March 23, 2015

Memo To: Nell Donaldson  
Barbara Barhydt  
From: David Margolis-Pineo  
Re: 195 Kennebec Street – Century Tire (2015-027)

FST 100 YEARS	FAY, SPOFFORD & THORNDIKE ENGINEERS - PLANNERS - SCIENTISTS 778 MAIN ST., SUITE 8, SOUTH PORTLAND, ME 04106
DRAWN: KGS	DATE: 6/9/15
DESIGNED: ADJ	SCALE: AS NOTED ON PLANS
CHECKED: ADJ	JOB NO: 15-018
FILE NAME: SP-1	SHEET: C-7.0

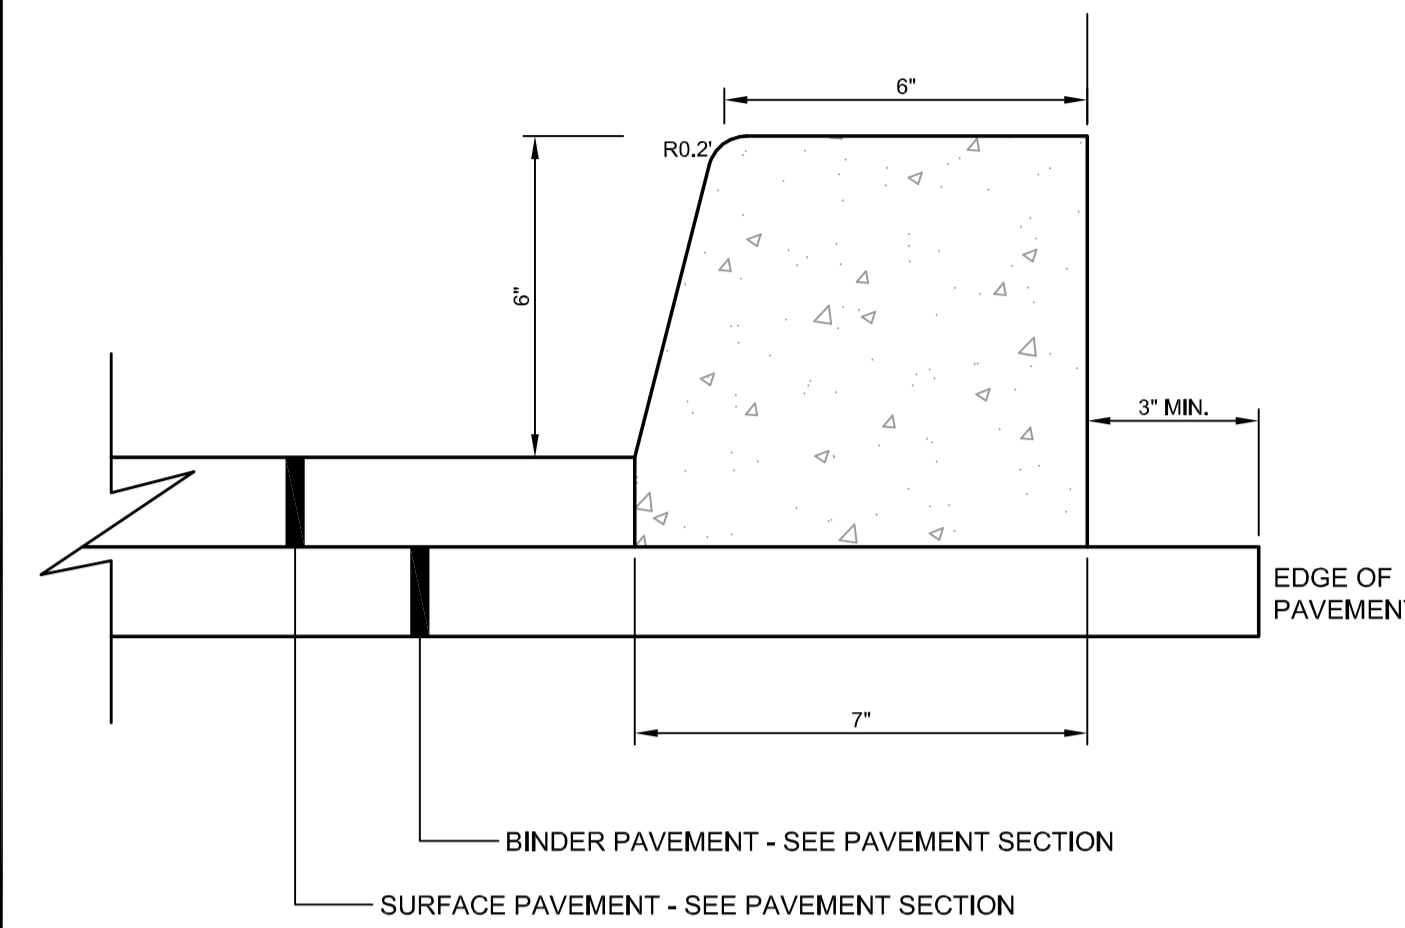
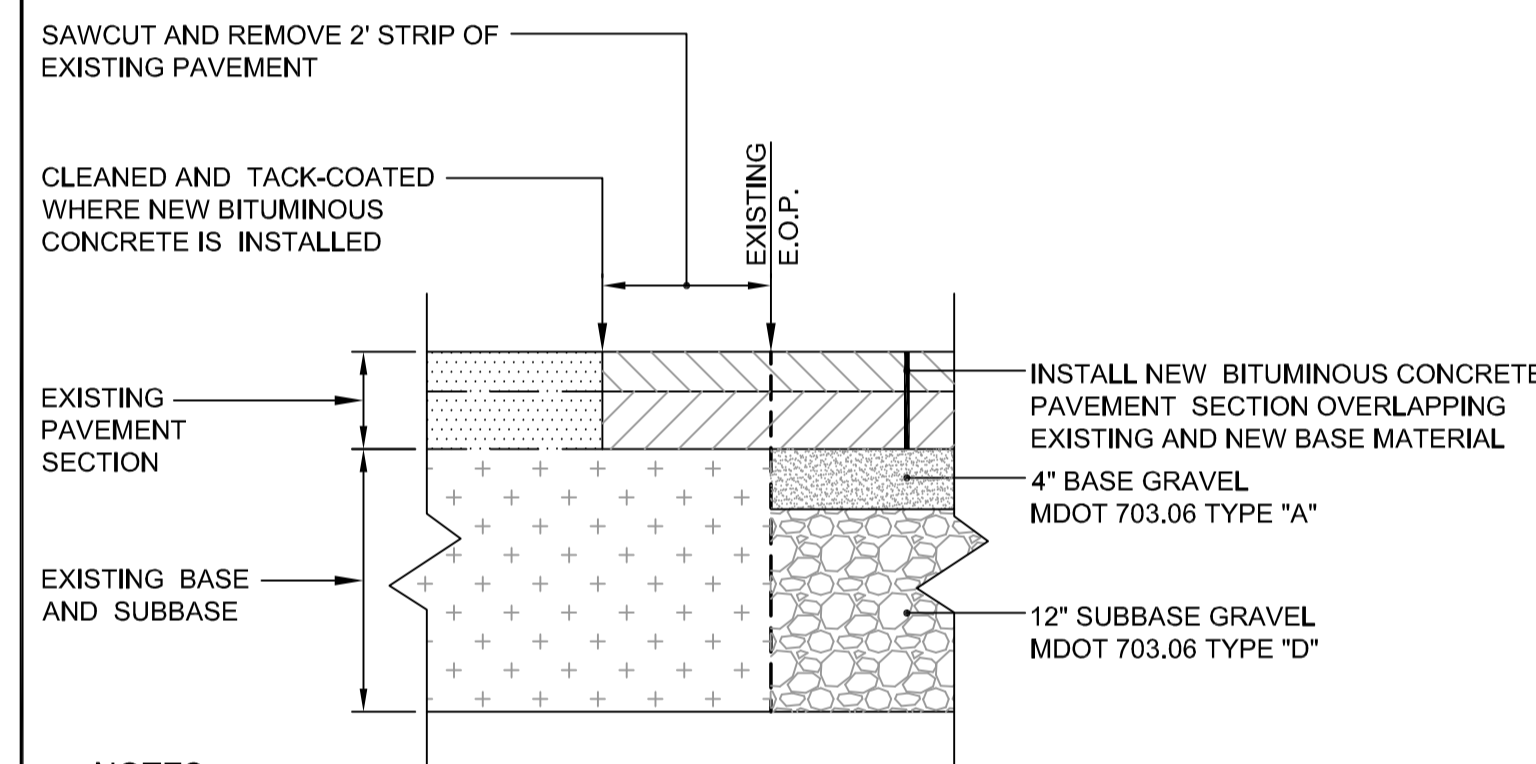
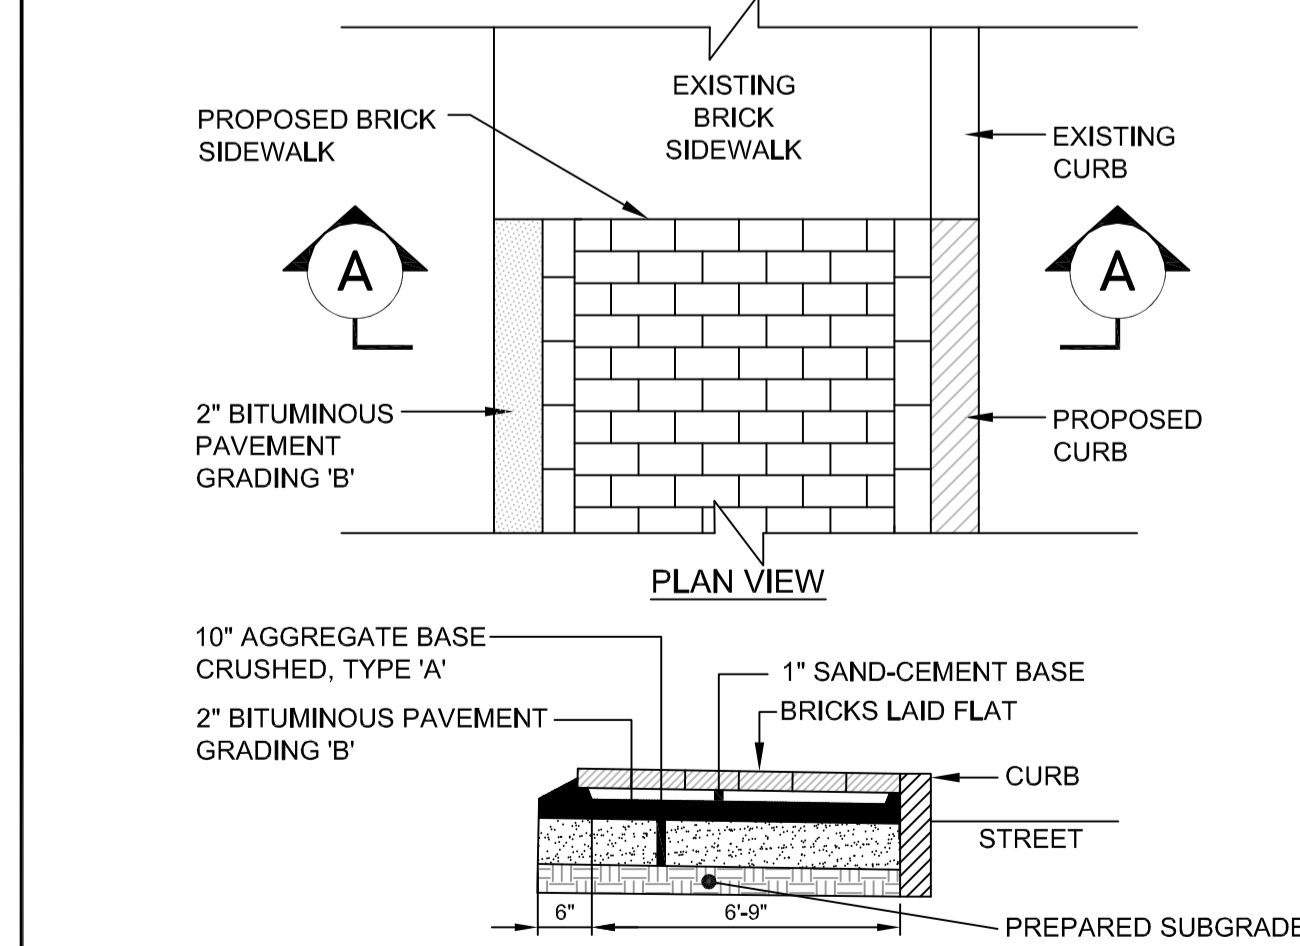
1. Street lighting standards for Kennebec and Marginal Way need to be determined.
2. Note: Sidewalk warning panels not required across driveway entrances. No response necessary.
3. The curbing material standard within the road right of way for the City of Portland is granite. Concrete is indicated on Kennebec St
4. Since Marginal Way will have a new separated stormwater system in the near future, is it possible to convey drainage from existing CB A to proposed CB 1 and abandon lateral from existing CB A to CB with a rim of 10.30 in Kennebec St?
5. Surveying comments from Bill Clark forwarded directly to John Swan.
